Application No: FG/24/20/HH
Site Address: 31 Cissbury Road Ferring BN12 6QL
Description of works: New garden building.

Thank you for your internet representation made on 1st June 2020 which has been recorded as an objection with the comments as follows:

East Front Elevation

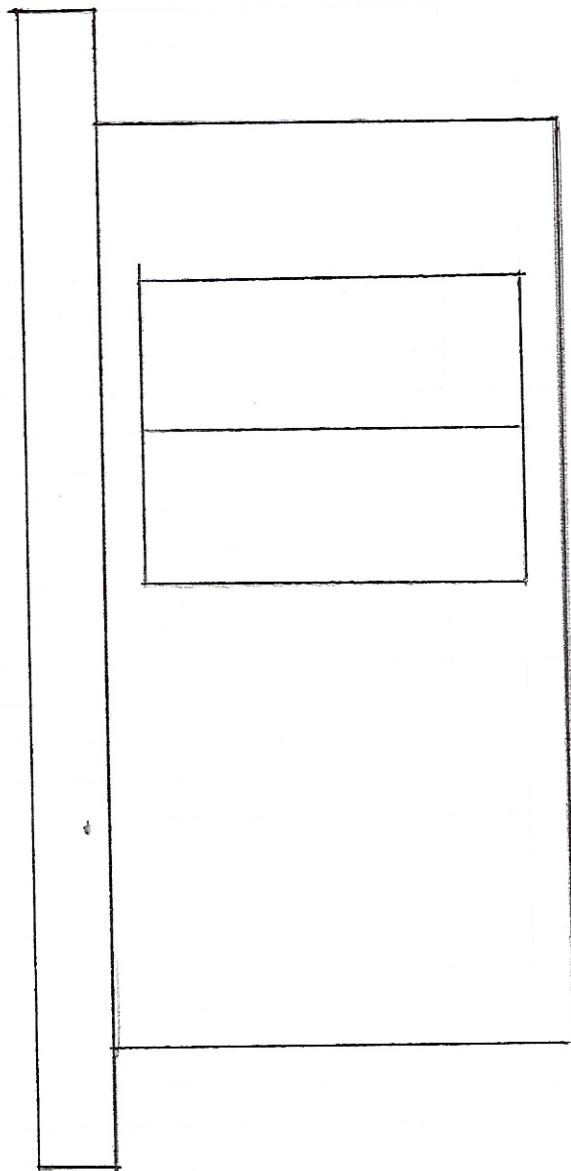
Firstly, the structure is too large for the purpose given; it is admitted to be over 2.5 m high. It is designed for more than a store for cycles and garden equipment. It is much more suited for use as a gym or workshop. Both of these uses would create unacceptable levels of noise.
